SICEEP, SOUTH EAST PLOT (SSDA9) –RESPONSE TO PUBLIC SUBMISSIONS

Peak Apartments

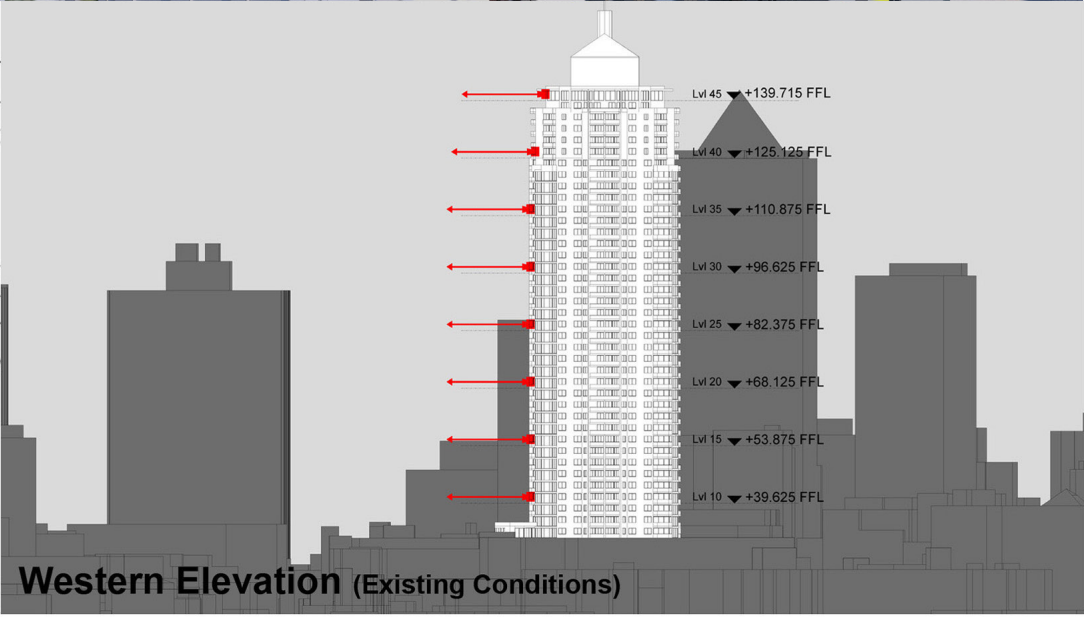
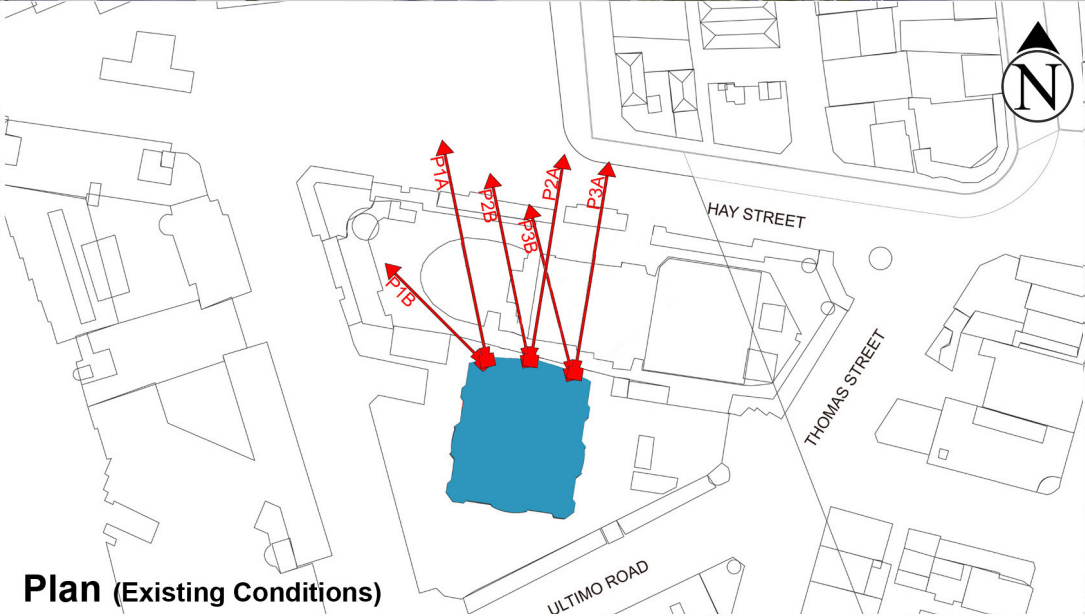
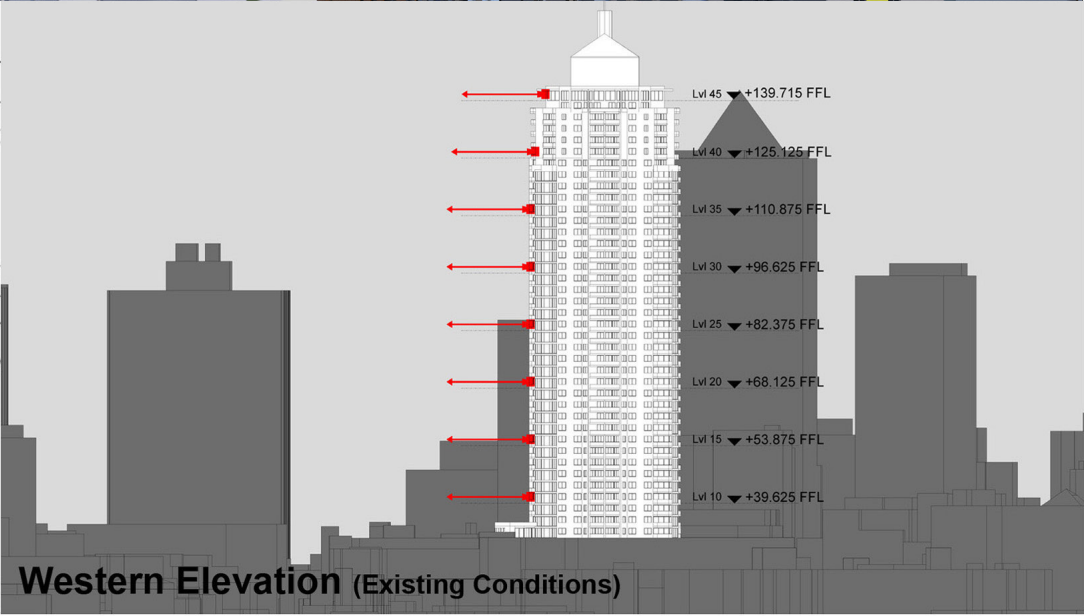
1	The proposal will significantly reduce views of Darling Harbour and Tumbalong Park from The Peak Apartments.

No. of times raised in Submissions	Item Raised	Proponent's Response
		The proposed development's response and relationship/compliance with the approved building envelope is considered to deliver a high quality, refined and articulated built form outcome as outlined further above in response to other matters raised in public submissions. The proposal achieves a well struck balance between responding to the important Haymarket setting of the development as well as its new urban renewal/modern context.
Overshadowing		
1	Buildings more than 9 storeys affect sunlight to the area including the new square limiting their access and use by local residents.	The shadow studies prepared in support of the Stage 1 Development Application (SSD_5878) reveal that the extent of additional overshadowing as a result of the Concept Proposal (including the South East plot building envelope which accommodates the subject Mixed Use Residential Building) is appropriate and reasonable and will afford the new square (having regard to its Global City context) with an acceptable level of sunlight/daylight across the year. With the subject SSDA9 being wholly contained within the approved building envelope for the South East plot, the overshadowing impacts resulting from the proposed mixed use residential building are appropriate and consistent with the Stage 1 approval.
